Our Ref: Y/140/20/DOC

Approval of details reserved by condition following Y/32/17/OUT relating to conditions 6-scheme to deal with the risks associated with contamination of site, 7-drainage strategy details, 8-surface water drainage scheme, 10-SuDS system, 19-lighting details & 23-details & timetable of decentralised & renewable or low carbon energy resources.

Cinders Lane Nursery And Works To The Rear Cinders Lane Yapton BN18 0JJ

Arun District Council have decided to **REFUSE details reserved by condition for the following reasons:**

HB1, Hydro Brake Manhole & Discharge from Sub Base Attenuation Details

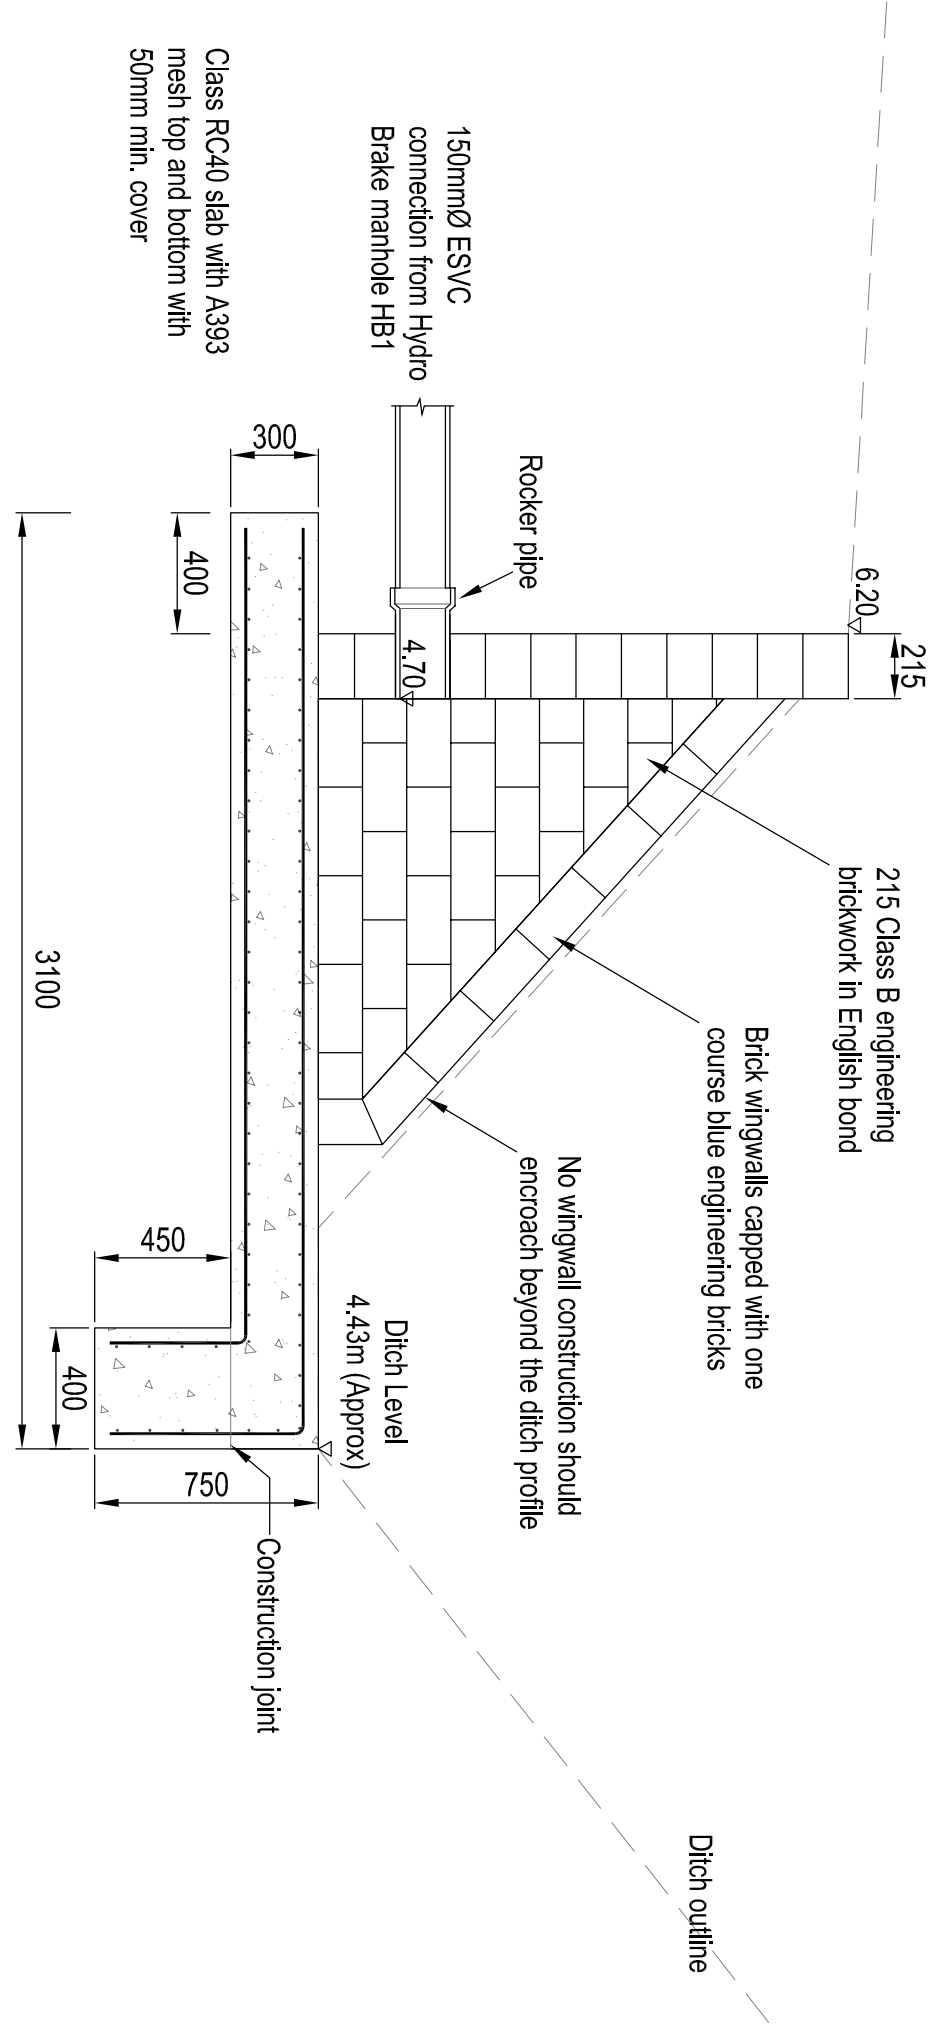
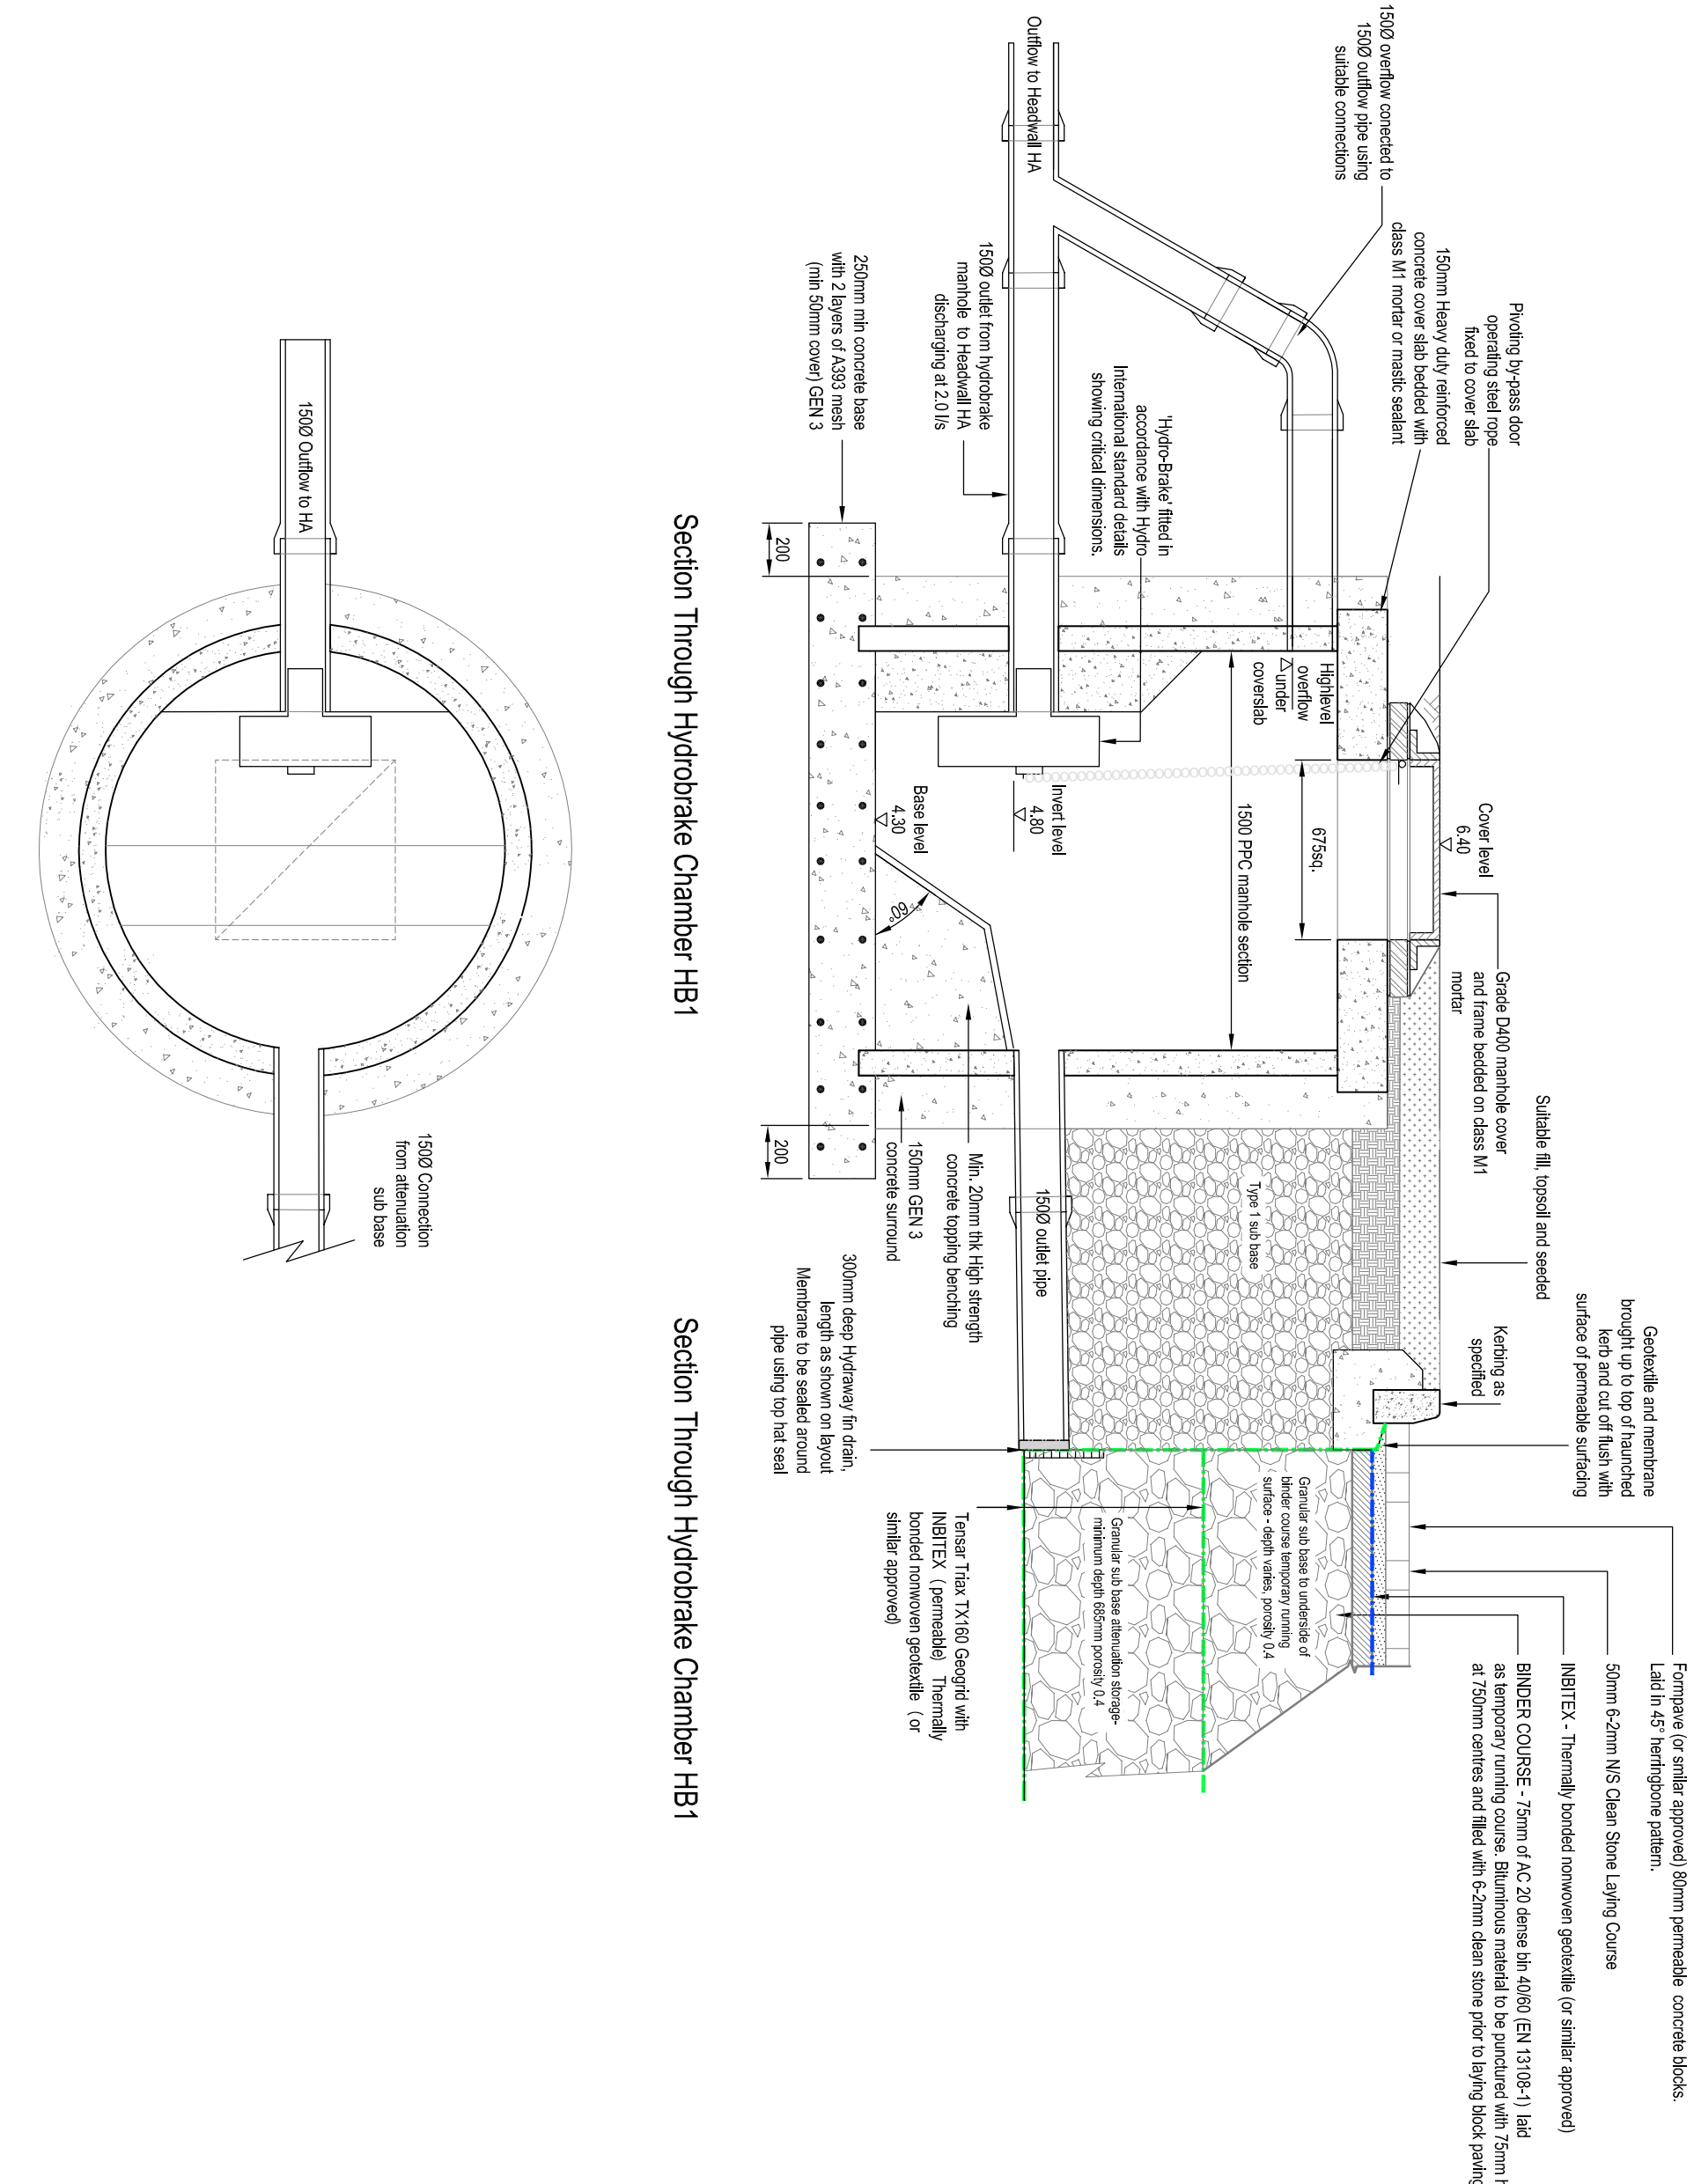
Southern Water have stated that they cannot recommend discharge of condition 07 regarding foul drainage as the provided onsite foul drainage layout does not demonstrate the drainage up to the final connection point with public sewer. They request that you submit a drainage layout plan with final discharge point to the public sewer. They also state that the proposed storage should be designed to be self-cleansing to prevent settlement of solids - they would recommend online storage in oversize pipes or additional storage discharging direct to the pumping station.

As such, the condition cannot be agreed at this time and you will need to make a revised submission.
